# PORTLAND MAINE

June 9, 2011

RE: 88 Cumberland Ave. - 13-M-008 – R-6 Zone – permit application #2011-05-1221

MORTGAGE INSPECTION OF: DEED BOOK 22378 PAGE 105 COUNTY Cumberland
PLAN BOOK -- PAGE -- LOT --

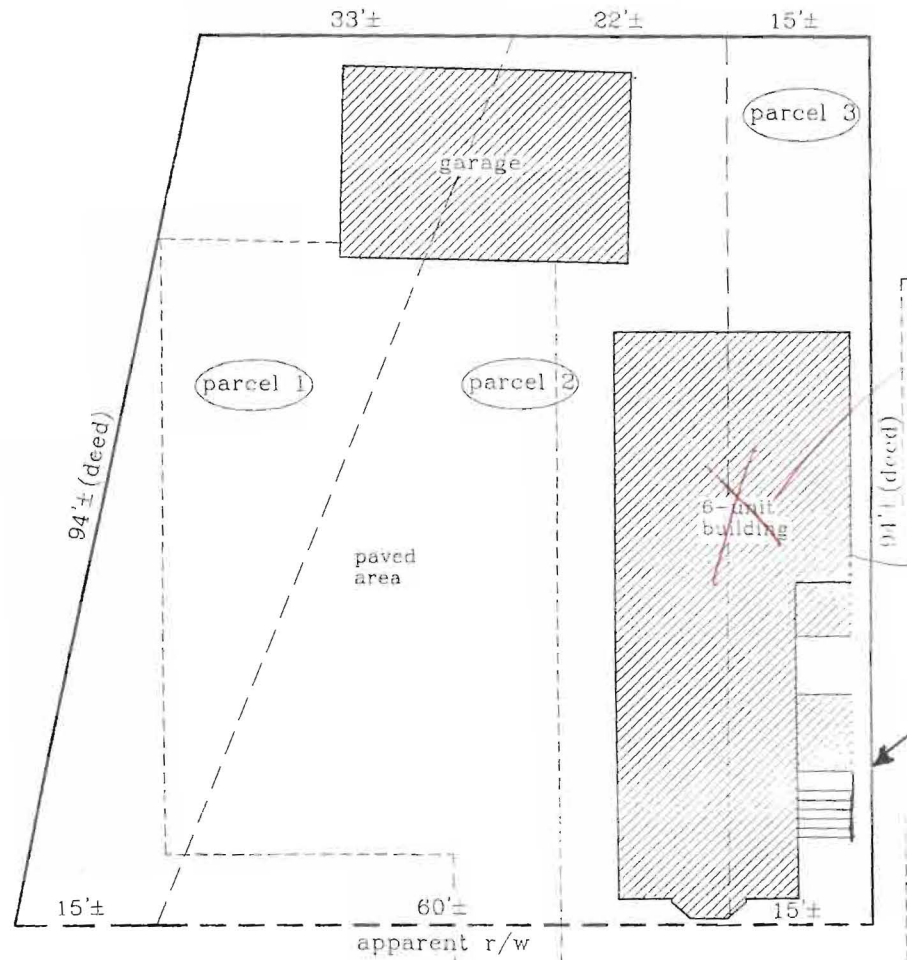
Your entry way is currently 2 feet from the side property line based upon a Class D survey submitted. Section 14-139.d.3 requires a minimum side yard setback of 10 feet. You are legally nonconforming for your existing structure, but you cannot increase your nonconformity (other than to permit the minimum under Building Codes to bring the entryway up to minimum safety standards –section 14-440).

I also want to point out that the legal use of this property is 5 residential dwelling units. Your Class D survey plan states that the building is a six unit building. Your contractor confirmed that there are only 5 residential units in the building. Please note that if there is a sixth unit, it must be removed immediately.

Deck Framing
Plan

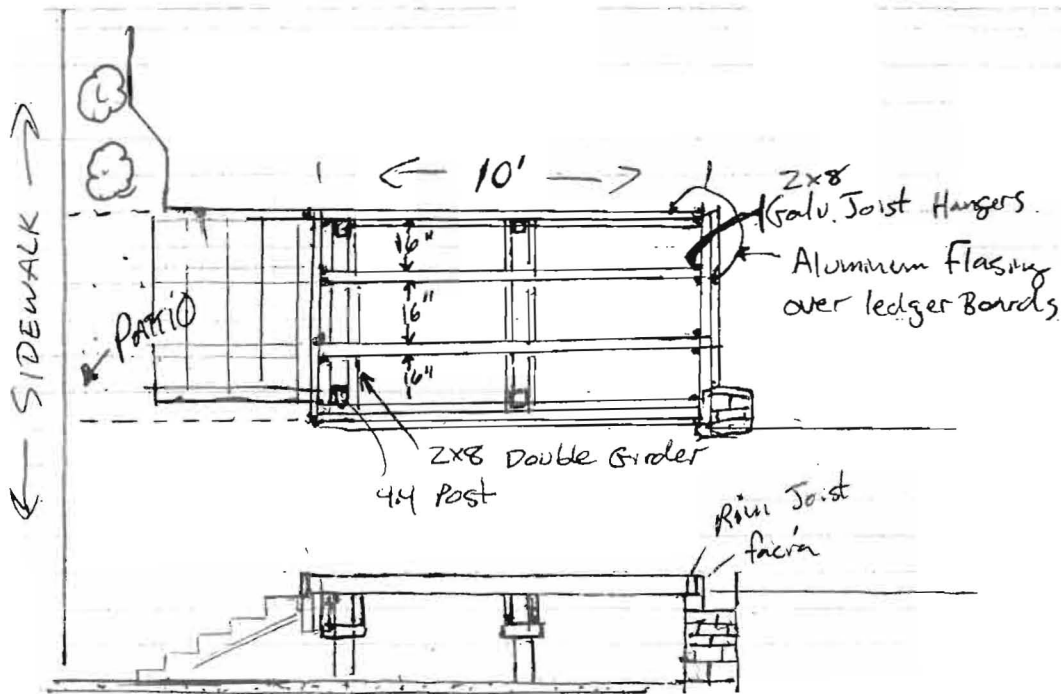
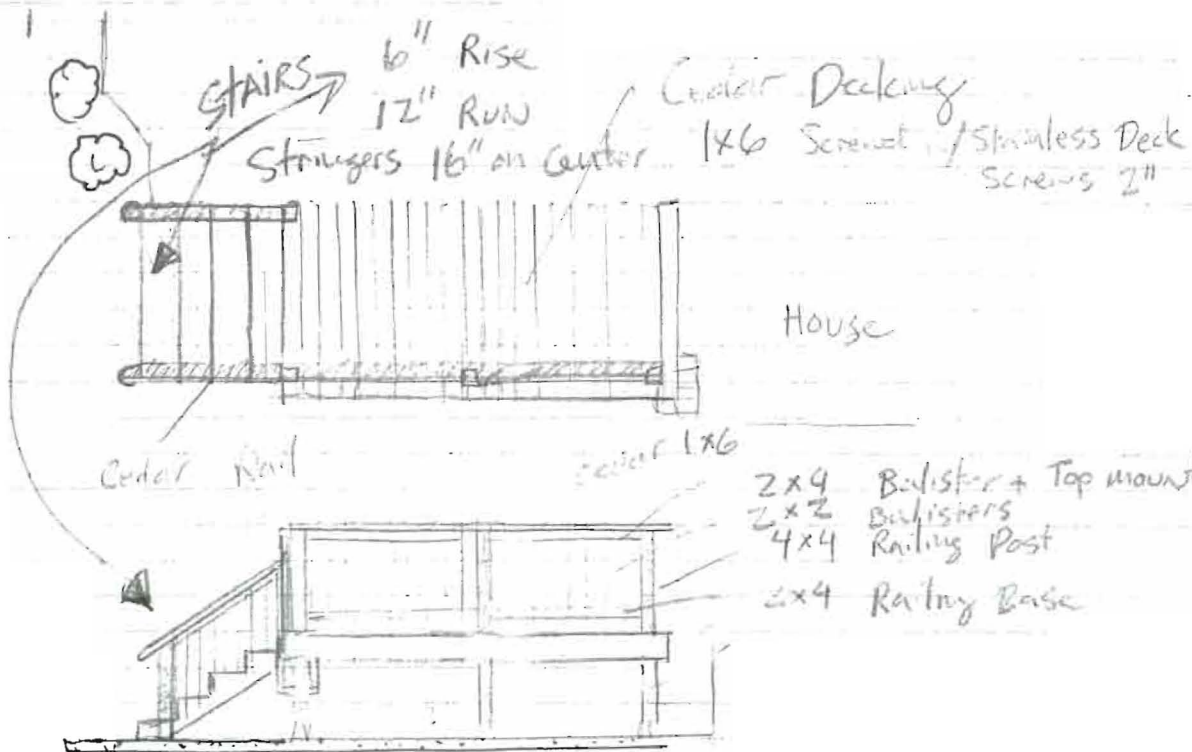
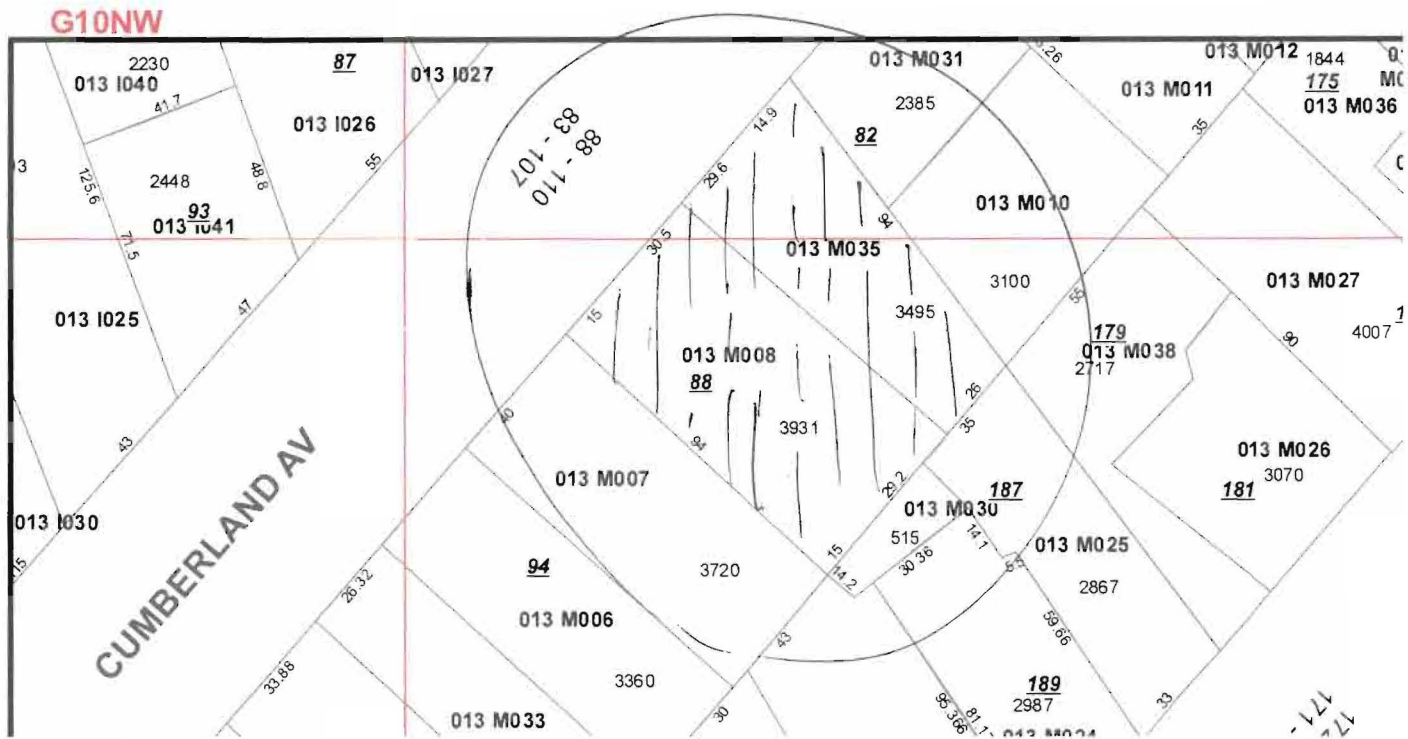
I am in receipt of a permit application concerning your property located at 88 Cumberland Avenue. You have asked to replace an existing entry stairway and to add an additional 8 foot deck to this property. Your permit is being denied because your proposal can not meet the required setbacks. It is also understood that currently your stairs into the right side entry do not currently have a landing before entry through the door. This office would allow a minimum landing of 3 feet by 3 feet to bring the entry up to minimum building codes. However, this office cannot allow a deck 8 feet long.
